Permitting and Inspections Department  
Approved with Conditions

**Brian Stephens** <bstephens@portlandmaine.gov>  
To: Katherine Kayatta <kskayatta@gmail.com>  
Cc: Permitting and Inspections <buildinginspections@portlandmaine.gov>, Chris Legare <crlegare@gmail.com>

On 1/4/2019 I did make comments on you drawings requesting additional information about the framing. You can review the comments/questions and resubmit through the web portal. Please follow the instructions on the "Re-submittal Required" email.

First Floor Sketch – 141 Beacon Street

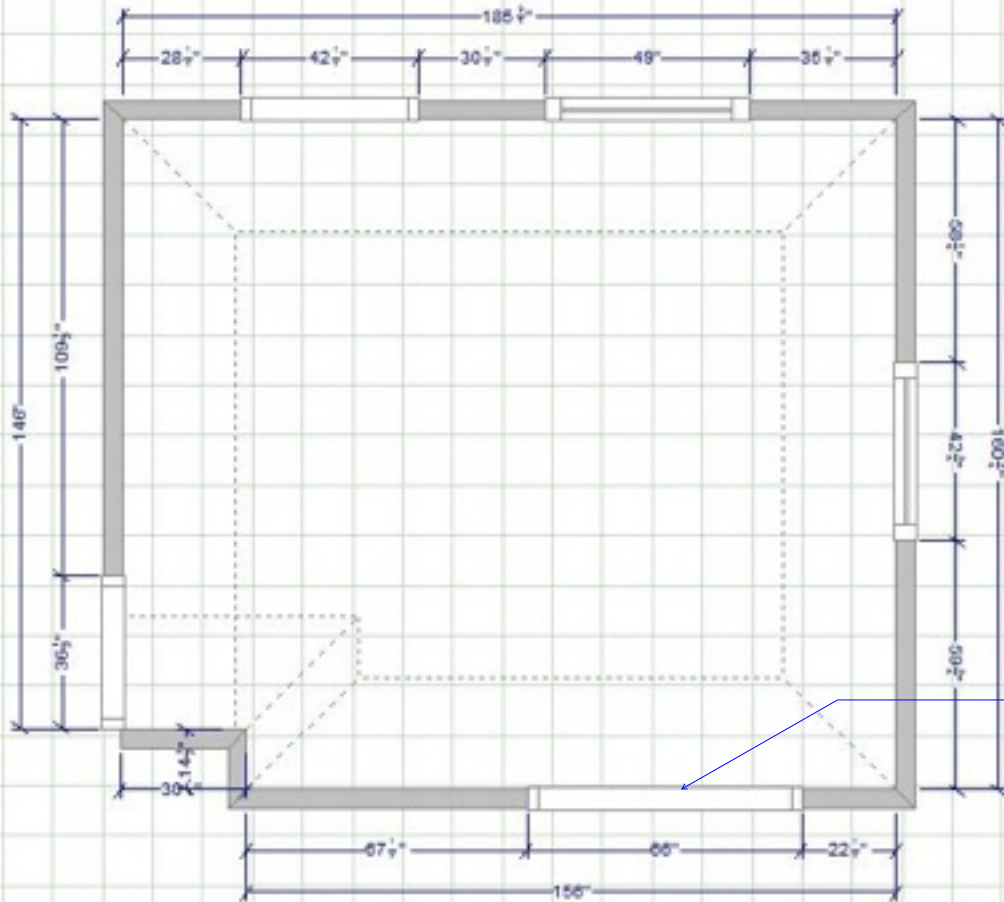
I responded through the portal under "collaboration" but I'm also emailing as I don't know how to use the portal very well and Chris is likely on a work site today without a computer (he texted me his login so I could check your comments on the portal) To answer your question, yes, the place you marked on the drawing is the opening to the dining room.

The plan is to return the doorway to it's original size. You can see the seams on the plaster wall from where the original larger doorway was framed in to be smaller. We are simply opening it back up to it's original size to match a doorway on another wall. The new opening will be 29 inches wider and 12 inches taller. There is an existing header for the larger opening already inside the wall.
